Re: Hamilton Test Facilities at 1500 Broadway N.E. and  
9805 Central N.E. - Certificates of Occupancy.

RE: HAMILTON TEST FACILITY DRAINAGE PLAN DATED 6/18/82  
(FILE NO. J14-D21)

DRAINAGE REPORT  
FOR  
HAMILTON TEST FACILITY  
1500 BROADWAY N.E.  
ALBUQUERQUE, NEW MEXICO

AS-BUILT DECEMBER 13, 1982 AS-BUILT GRADES IN PARENTHESES ONLY		DRAINAGE PLAN HAMILTON TEST SYSTEMS VEHICLE INSPECTION PROGRAM ALBUQUERQUE, NEW MEXICO		332309
SP-6		FLETCHER-THOMPSON INC. ARCHITECTS / ENGINEERS BRIDGEPORT, CONNECTICUT		SP-6

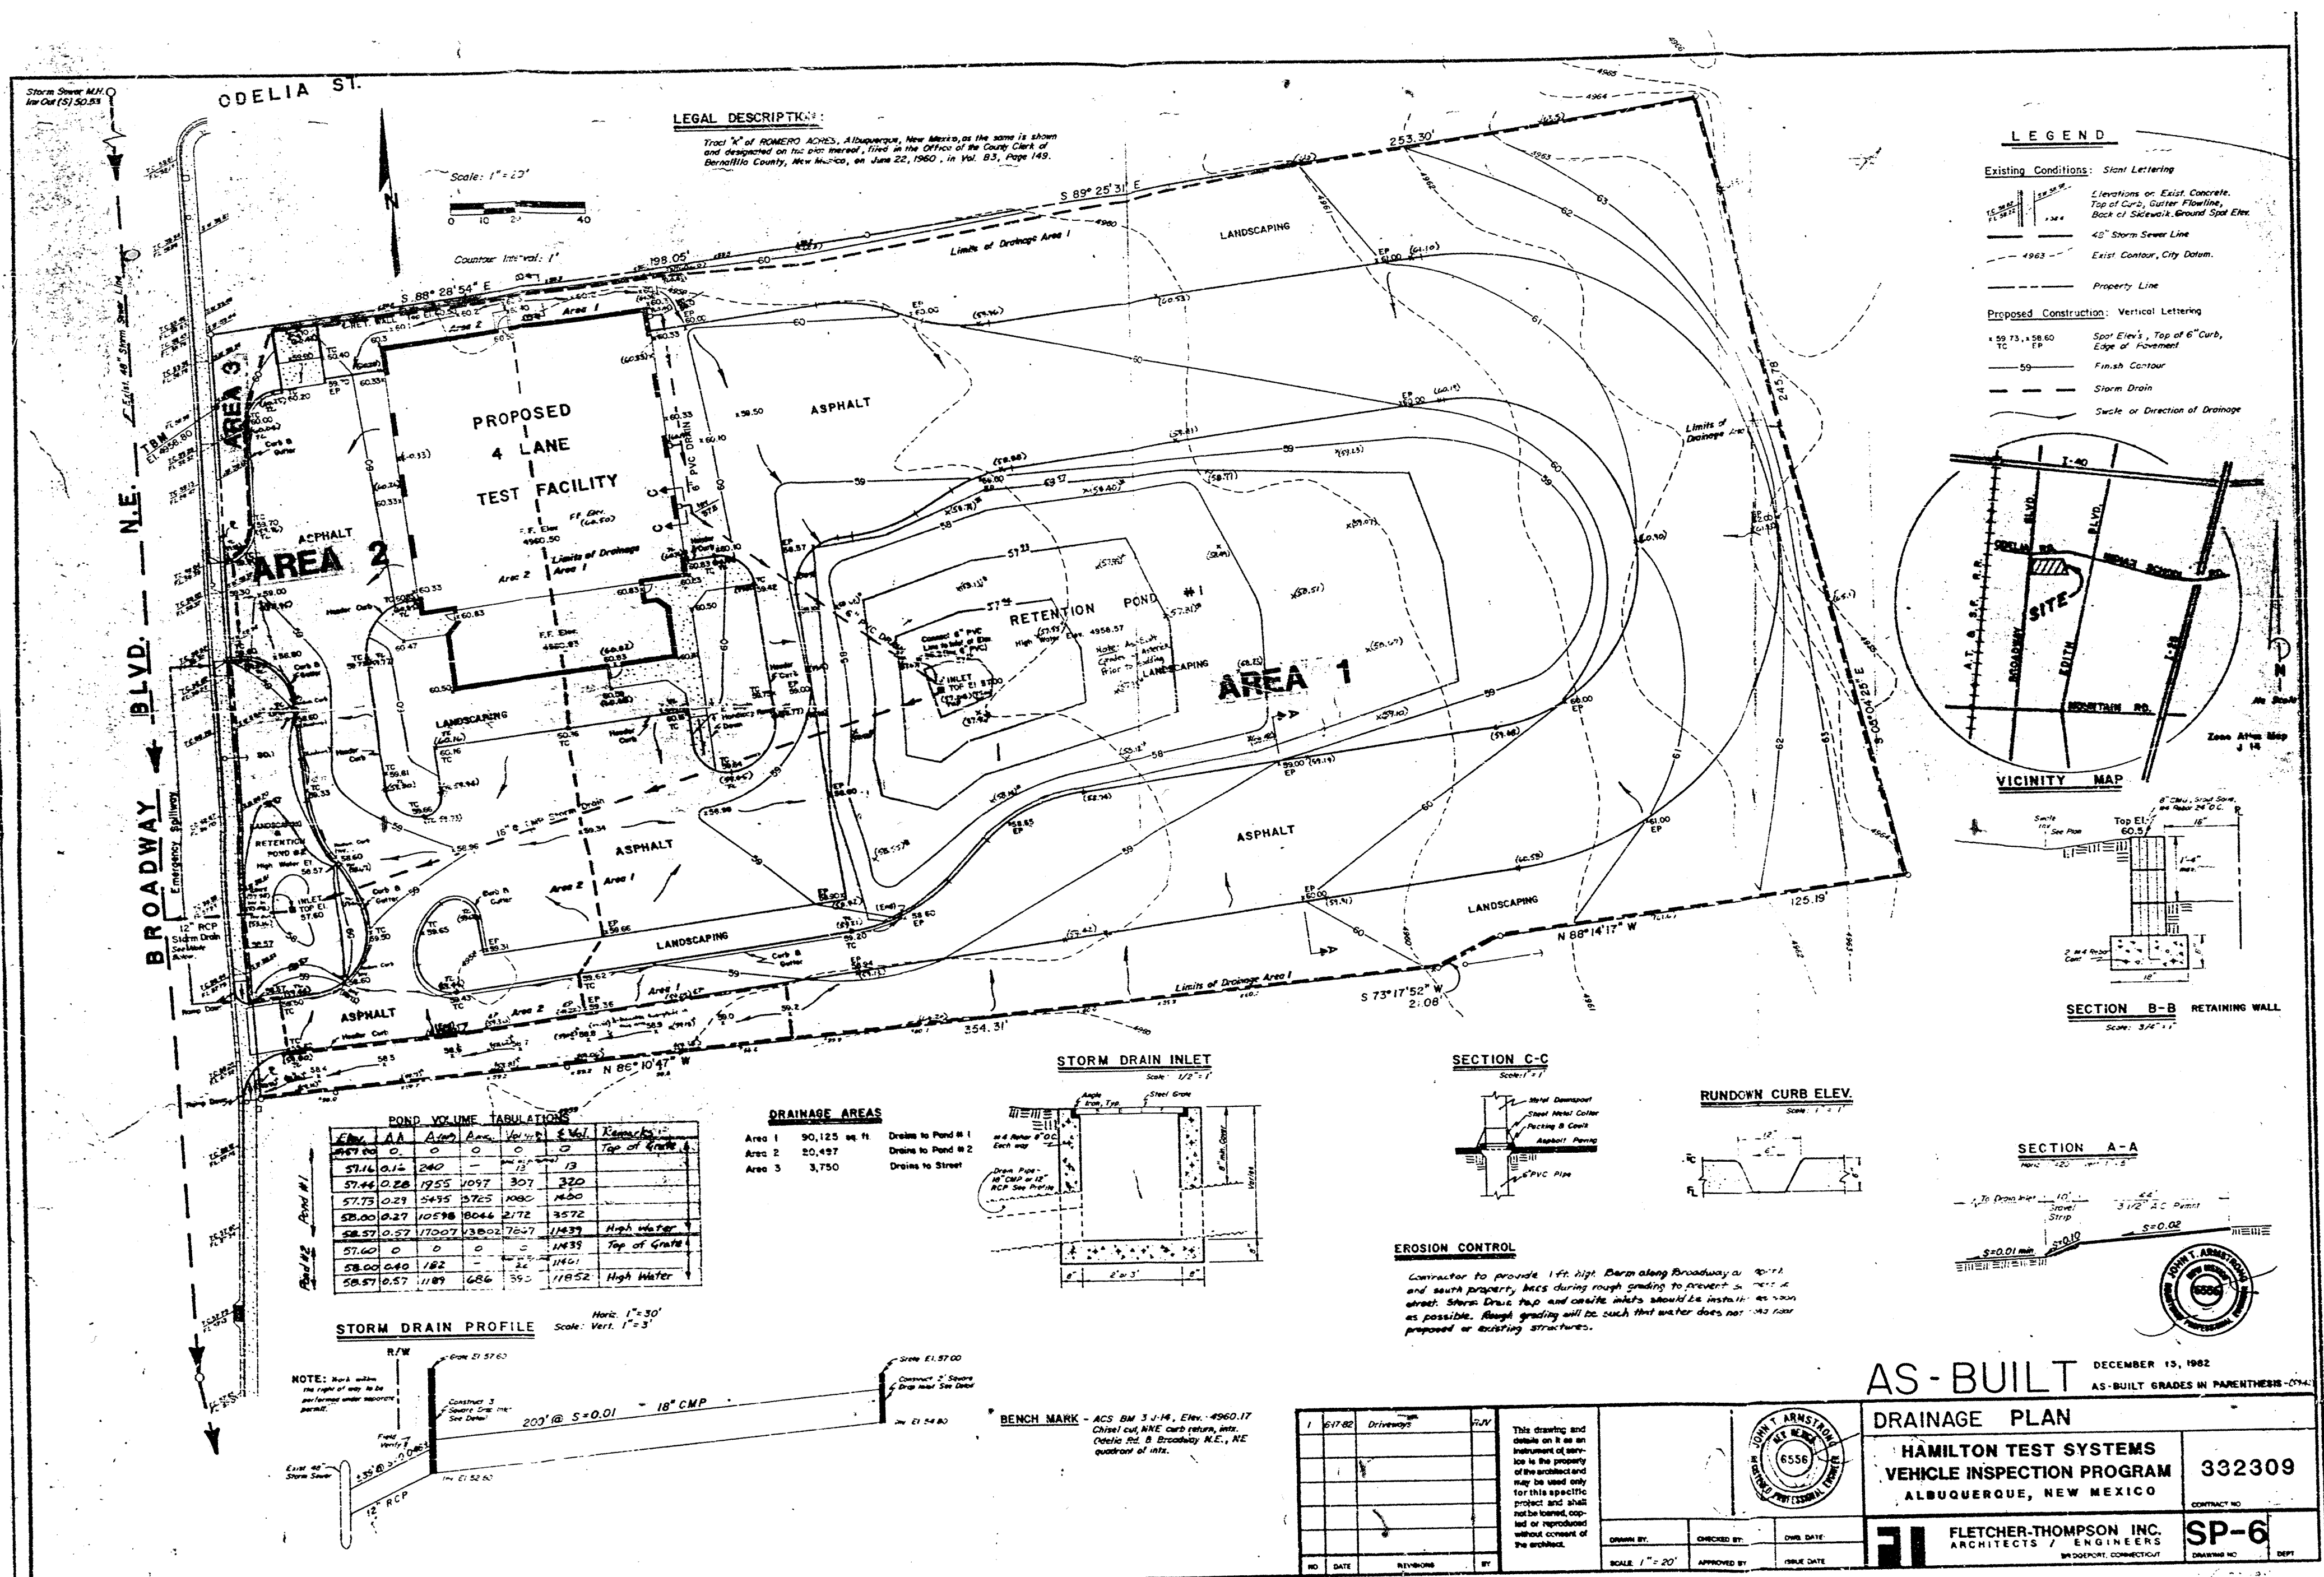
1. Completed Information Sheet - See Information Sheet. (Blank Copy Attached).
8. Erosion Control Plan - see Erosion Control Plan Checklist. (See item 24,N,3 for specific concern).

- B. Legal description or current plat.
24. Proposed Conditions:
  - D. Internal contributory drainage areas, including roof areas, outlined on plan.
  - H. Notes defining property line, asphalt sidewalks, planting areas, ponding areas, and all other areas whose definition would increase clarity. (show limits of curbs on-site).

- M. Details of ponds, swales, rundowns, curb cuts, water blocks, emergency spillways, retaining walls, pond outlets, safety fences, cross-sections, spot elevations and supporting calculations when appropriate. All cross-sections must be drawn to standard engineering scale or adequately dimensioned. (Provide more detail of the 6" P.V.C. roof drain pipe, i.e., how will it be constructed?)
